Bowmans Creek Wind Farm (SSD-10315)
Request for additional information

I refer to the assessment of the Bowmans Creek Wind Farm (SSD-10315). The Department is requesting that you provide additional information on the matters outlined below.

BOWMANS CREEK WIND FARM

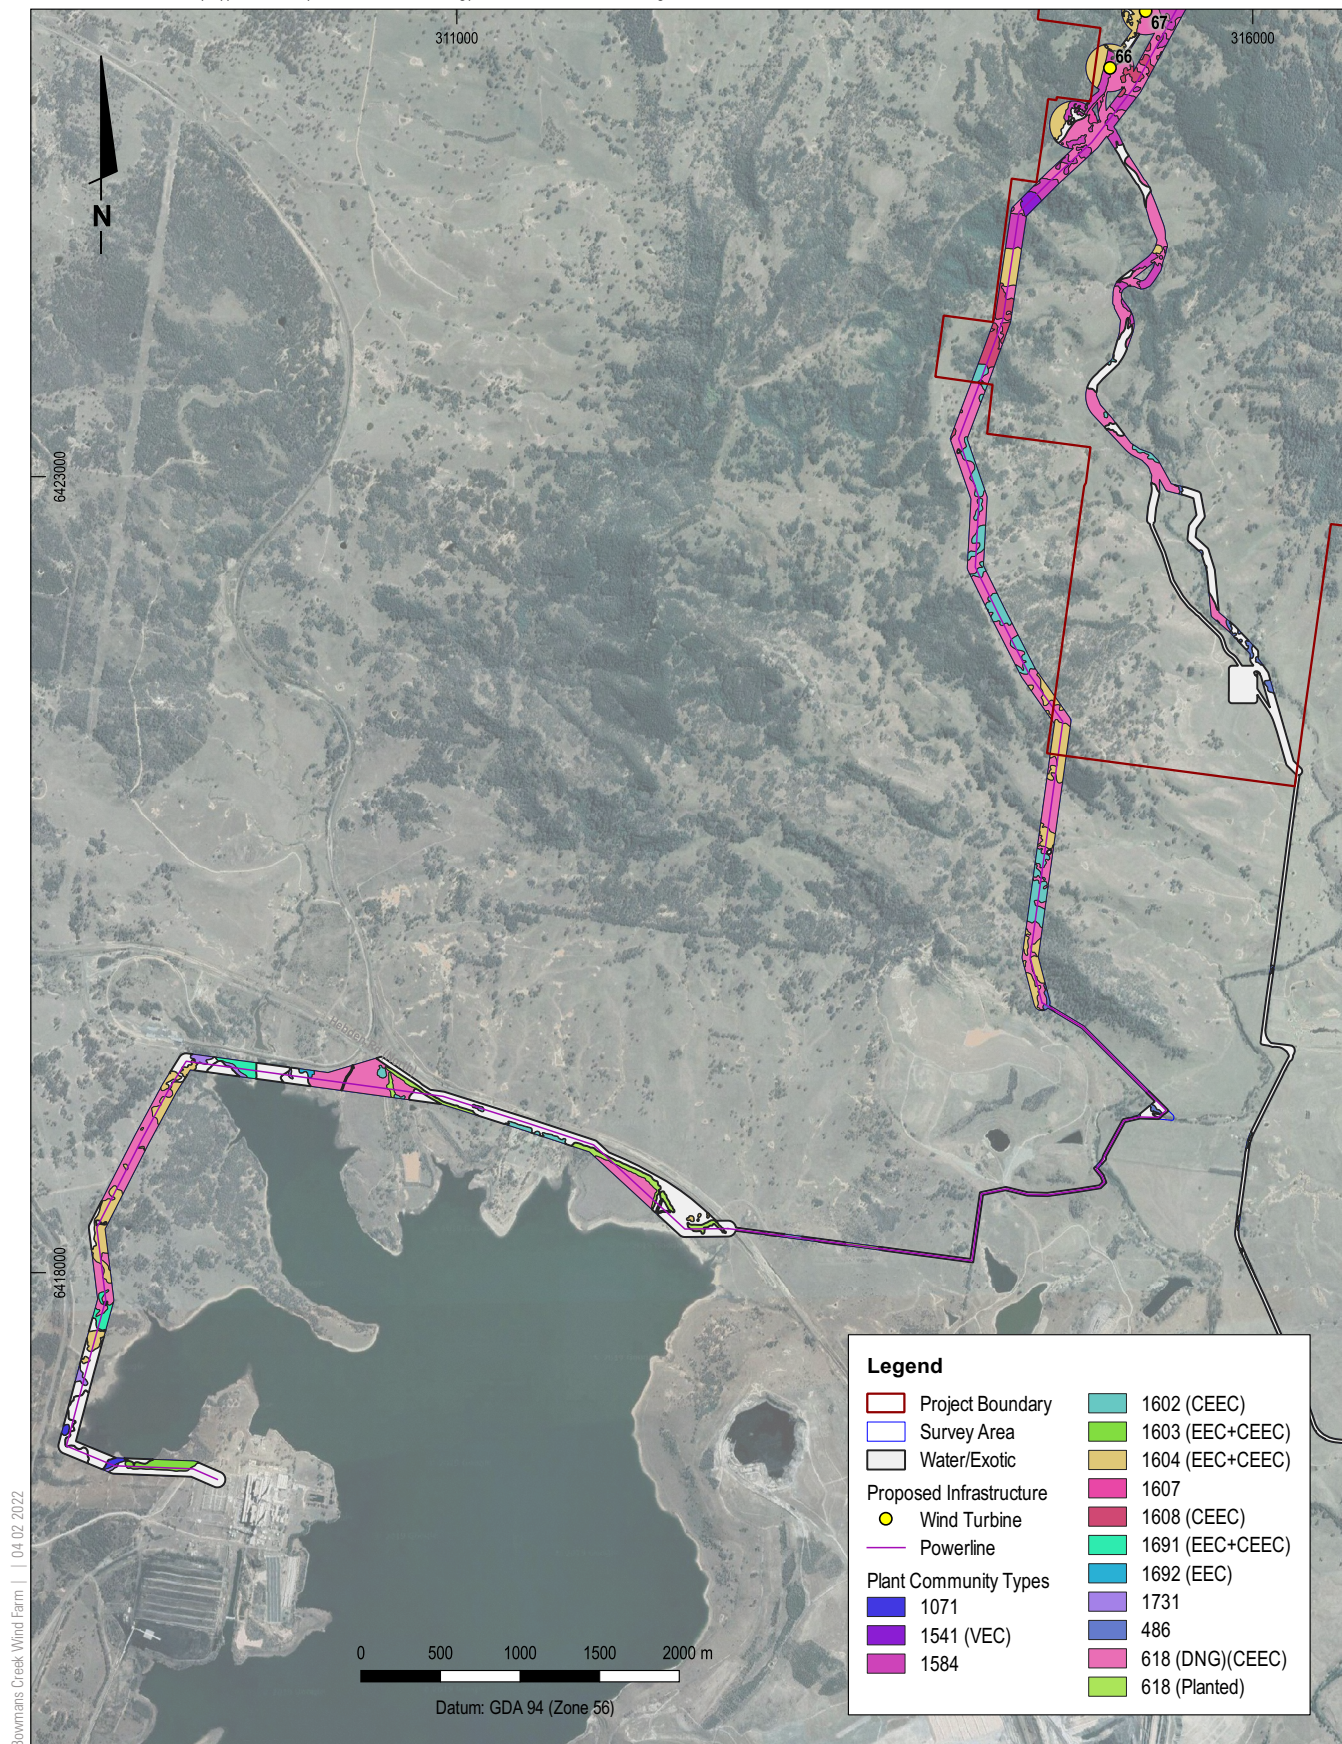
- Provide an updated version of figures 9 to 13 of the Amendment Report that shows the amended development footprint – identify turbines and key infrastructure;
- Once the schedule of road upgrades is finalised, confirm that all disturbance associated with road upgrades has been assessed; and
- Confirm which threatened flora and fauna species would be the subject of targeted surveys.

**FIGURE 1**

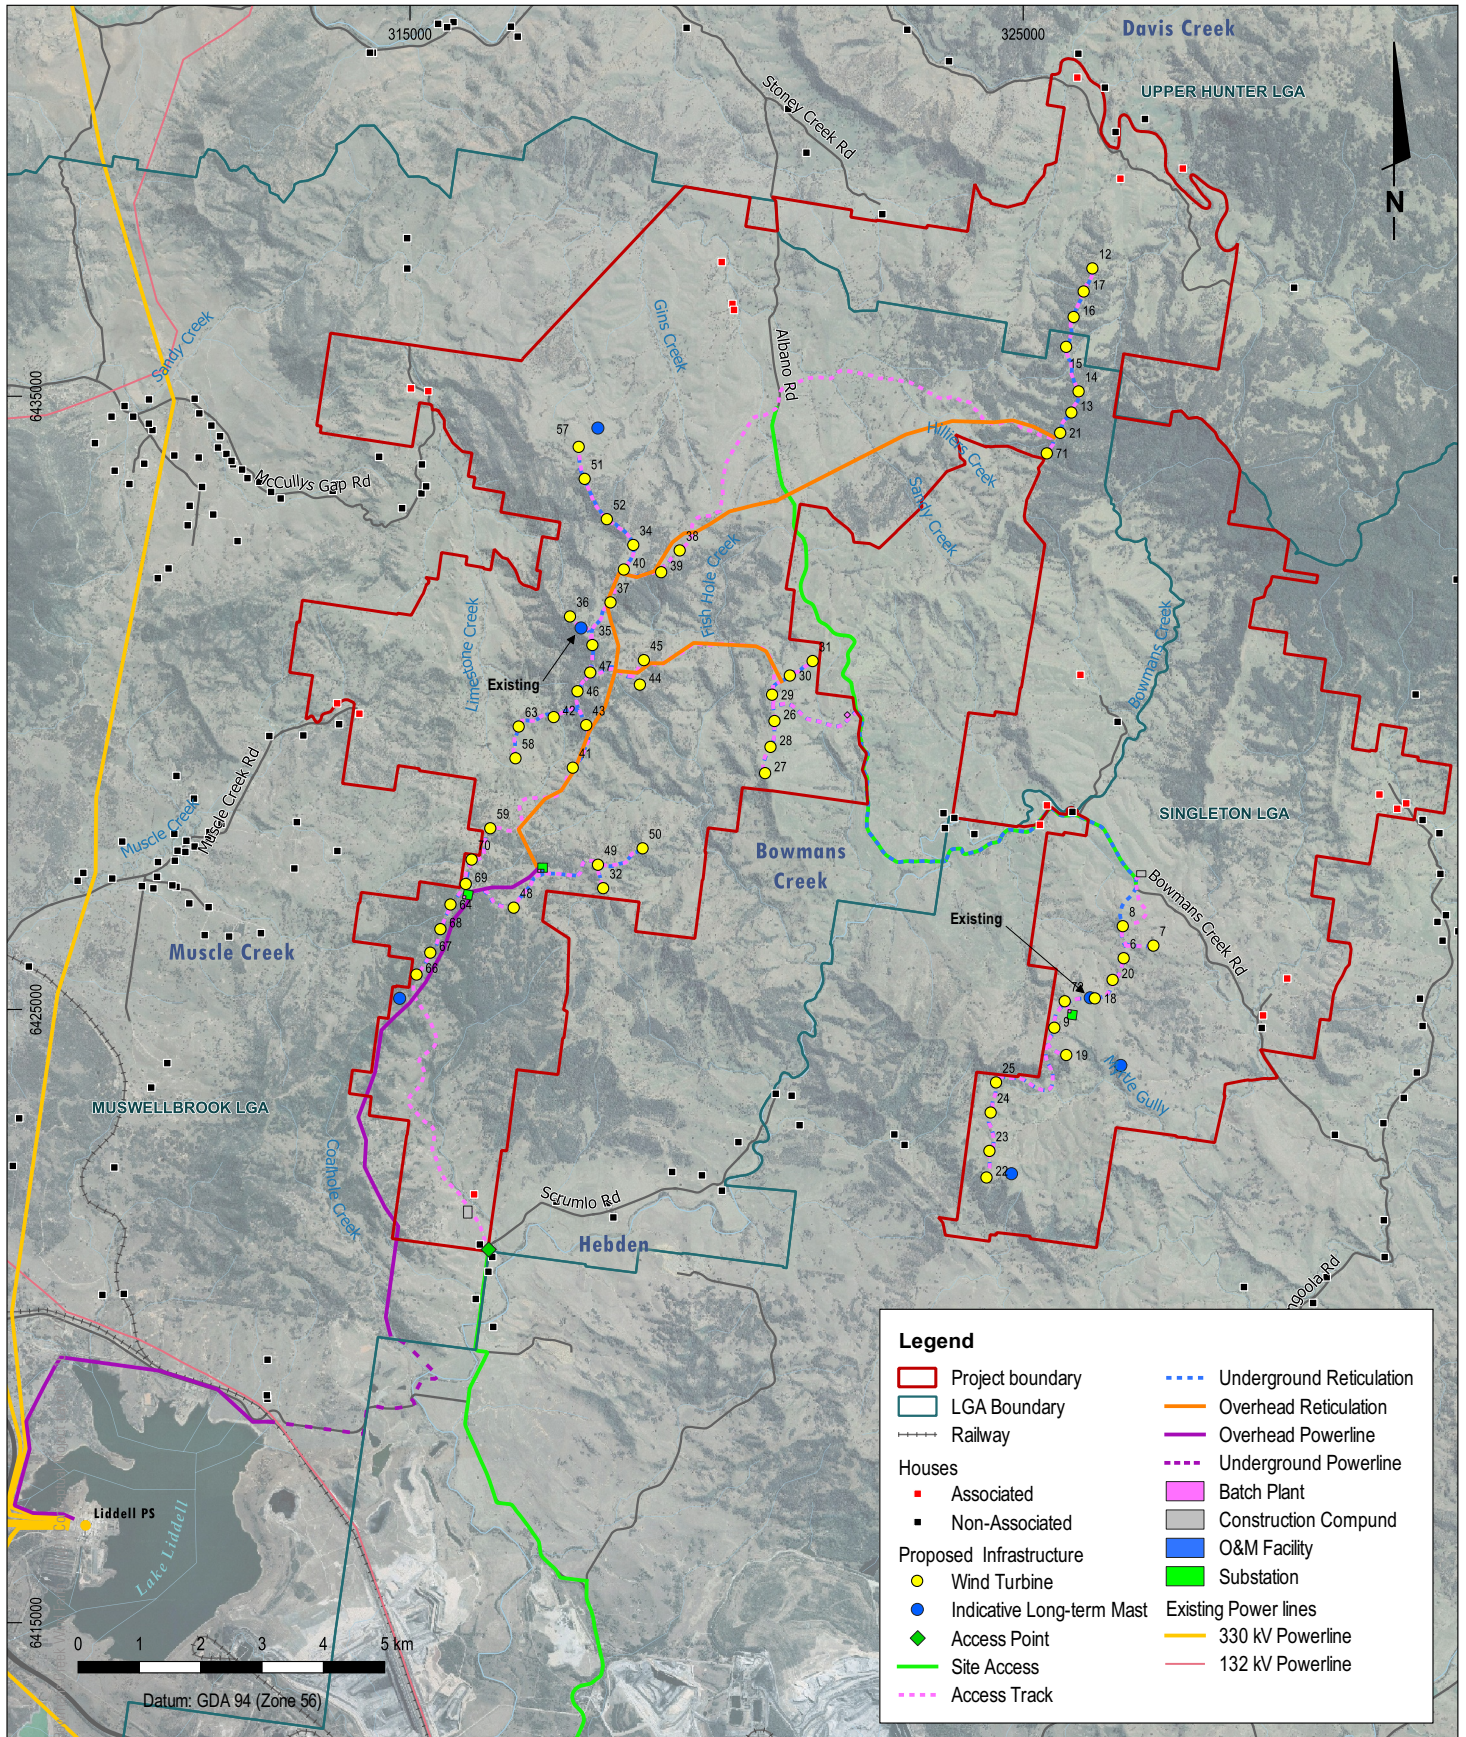
- *Regional Context (EIS Figure 2) and Project Layout (Amendment Report Figure 2)*: increase clarity and include key features, including satellite imagery, major roads, associated / non-associated residences; railways; waterways/creek lines; internal and access route roads;
- *Road upgrades*: provide an overview (regional scale) map of proposed road works, with location of works marked and cross referenced with the agreed schedule of works; and
- *Heritage*: provide a consolidated ACH and Historic heritage figure showing the amended project layout, including:
 - historic heritage sites (3 LEP listed sites, 2 new sites); and
 - Aboriginal heritage sites identified during surveys and the three AHIMS sites within the survey area (ensure sites are identified).
